Your Ref: 000013345
Our Ref: EP/70/12/ 27-06-2012
Please ask for:
Mr P Cleveland

Alterations & first floor extension, providing a reduced garden room on the ground floor, together with conversion of garage to a gym & 2 new bedrooms, study & bathroom to first floor. Removal of existing pitched roof & replace with lower mono pitched roof

Sandgate House South Strand East Preston Littlehampton

1207 SK26
 Sandgate House, East Preston
 Elevations As Proposed - sheet 2
 June 2012
 scale: 1:100

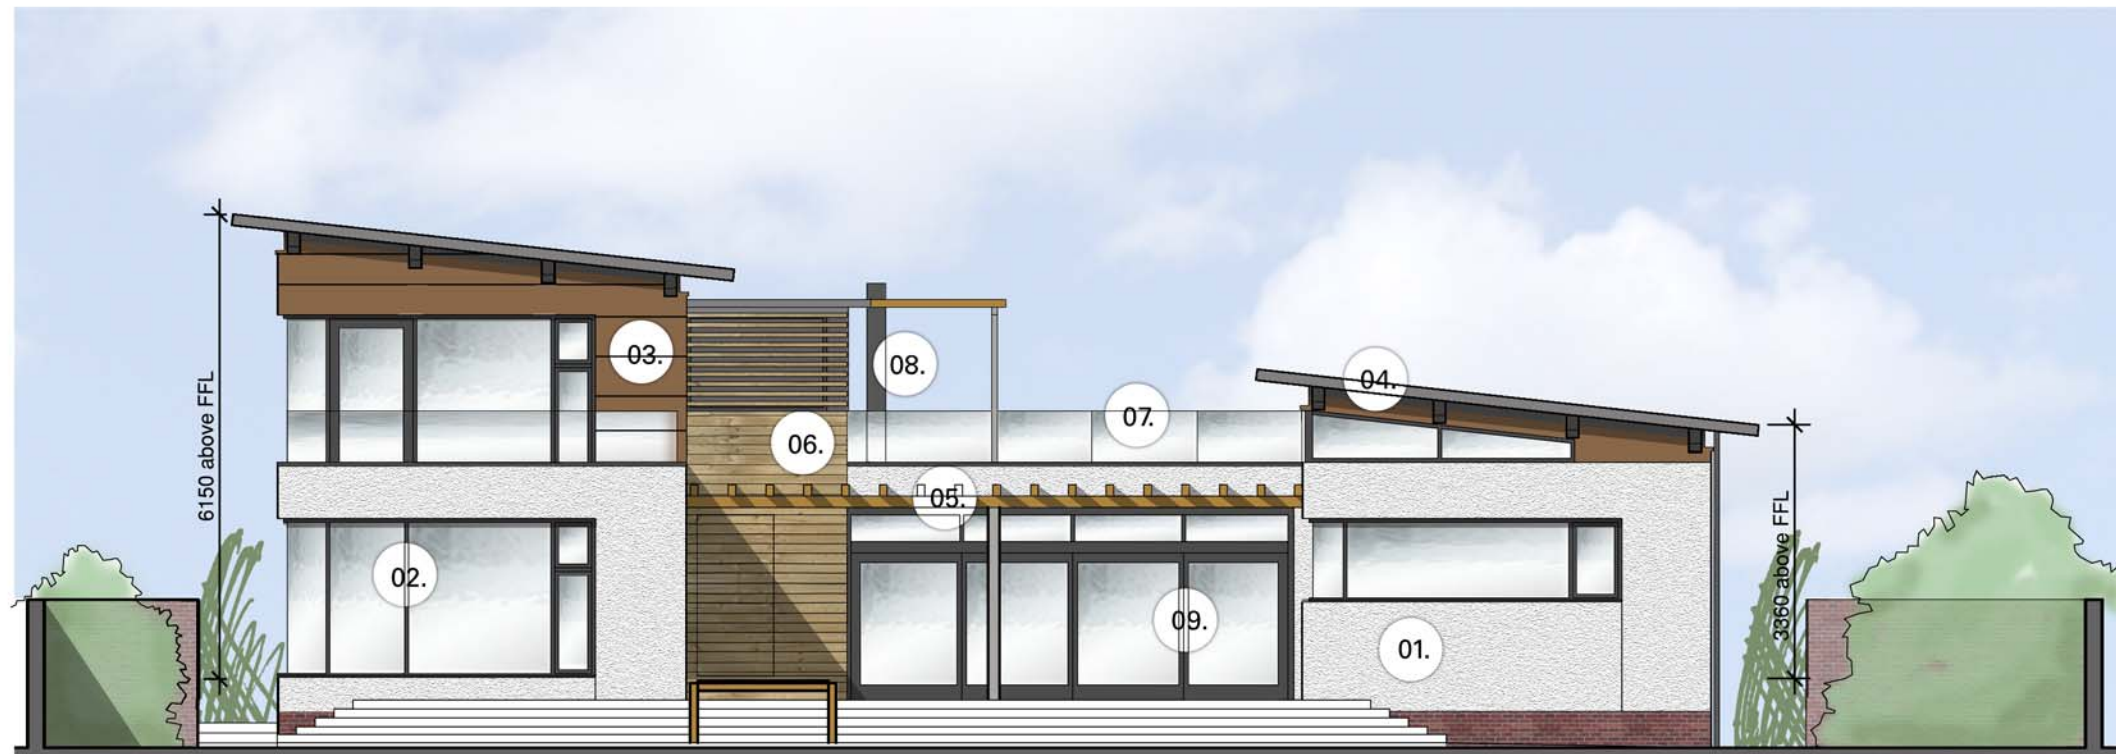
The proposal presents an overdevelopment by way of changes to the roof that will impede current views of neighbouring near seafront properties; the local authority refused a similar proposal to a property in the nearby area on the seafront, and it is hoped the application to over extend Sandgate House will be similarly refused. The Association was concerned to read that a garage was being converted to living accommodation (gym) which may cause parking problems.
